MECKLENBURG COUNTY
Park and Recreation Department

MEMORANDUM

RE: Rezoning Petition #2023-044
PID# 04705325

RZ-1

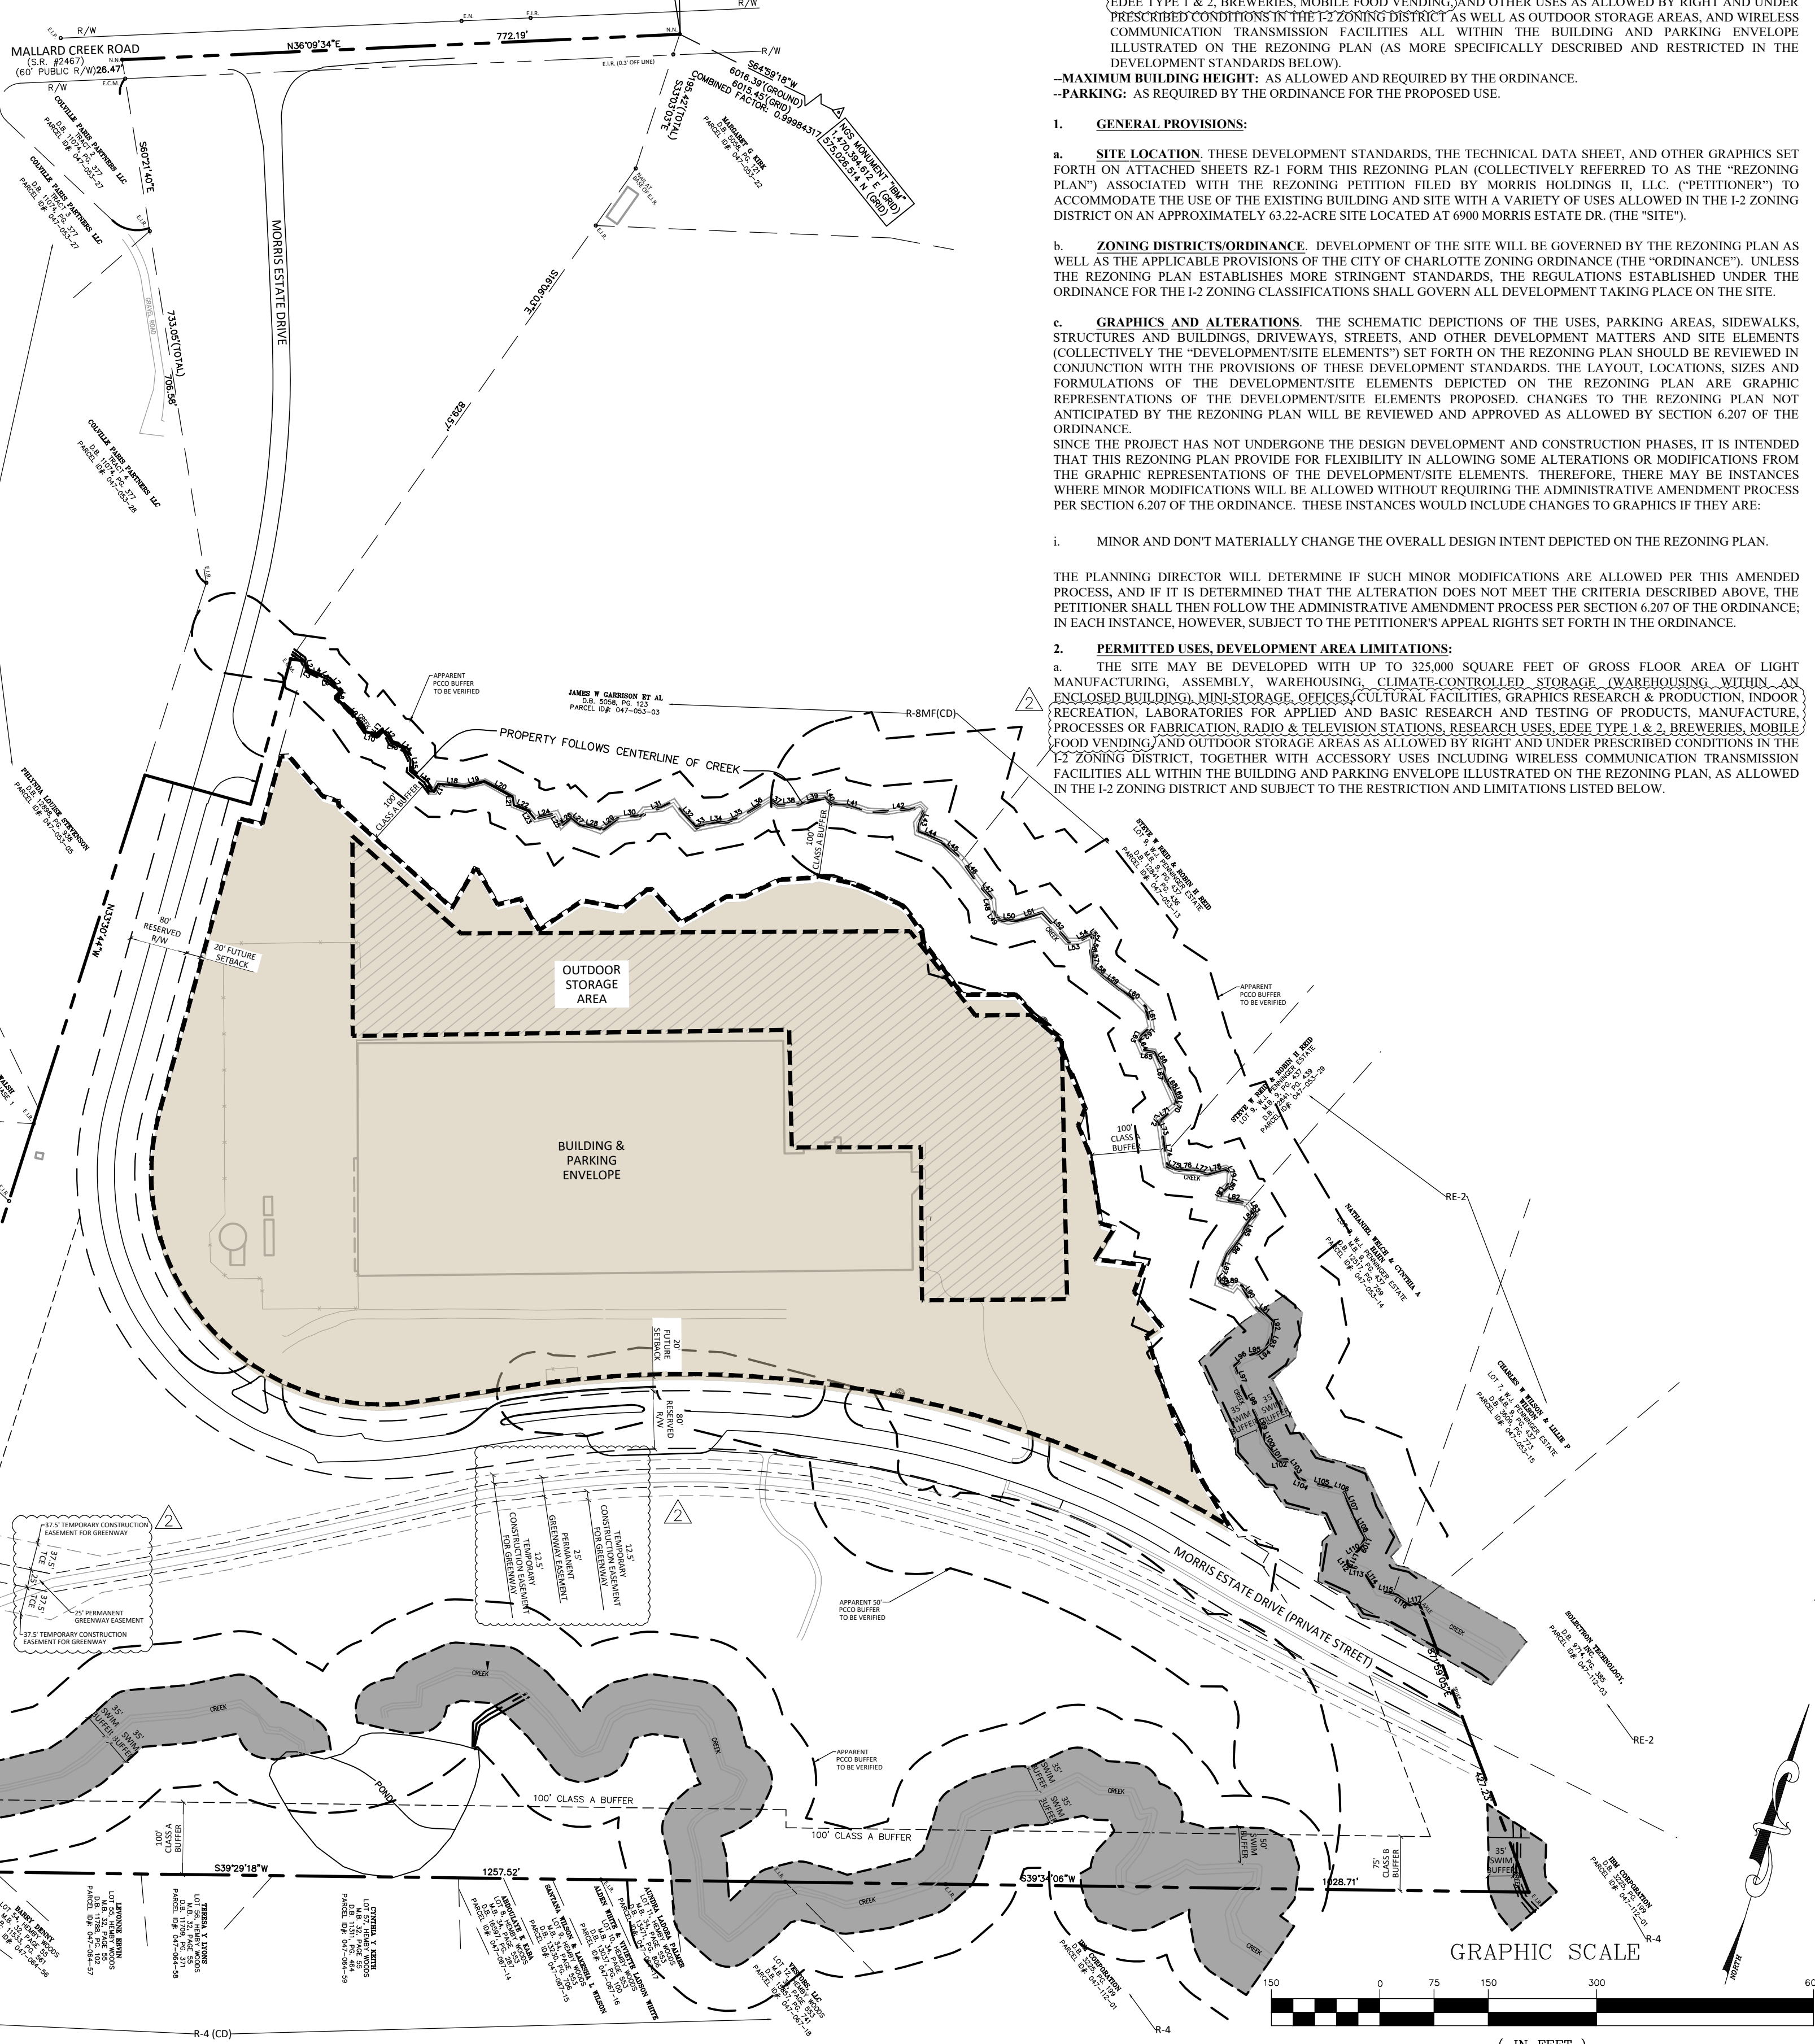
The proposed greenway easement shown on the site should connect to Nevin Road in the area generally shown in Plan Room. The additional requested greenway easement would allow an accessible bike/pedestrian trail connection to Nevin Road. Greenway easements shall be conveyed by the first CO and may overlap tree-save.
